**Subject:** RE: Millwood House, Littlehampton Road, Ferring, Worthing, West Sussex, BN12 6PG - FG/138/21/PL

**Planning Application Reference:** FG/138/21/PL

**Proposal:** Change of Use of land to open air storage (Class B8), including 12 equal sized open air storage yards, lighting and CCTV. This application is in CIL Zone 3 (zero rated) as other development.

location site

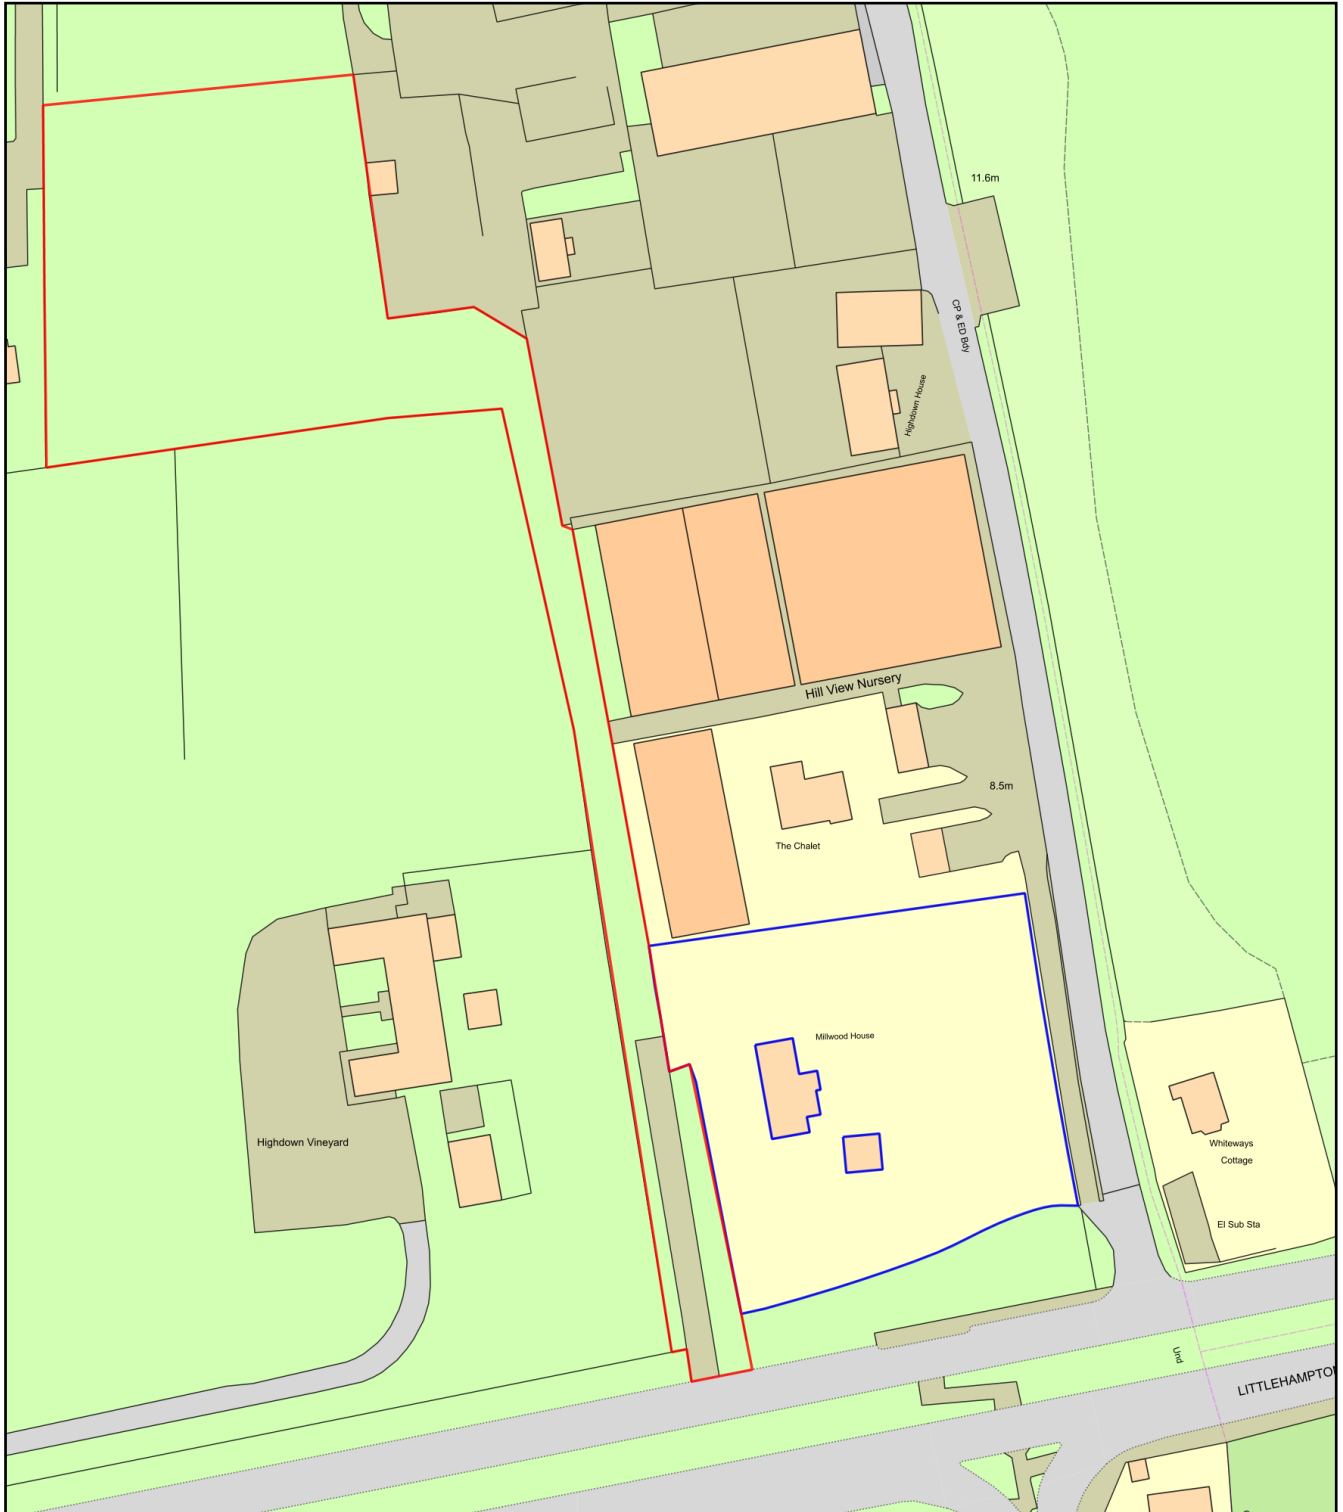
BEFORE THE FIRST OCCUPATION OR USE OF THE DEVELOPMENT the access roads and parking areas shown on the Location plan shall be completed with a hard surface finish and thereafter permanently retained for parking and manoeuvring purposes
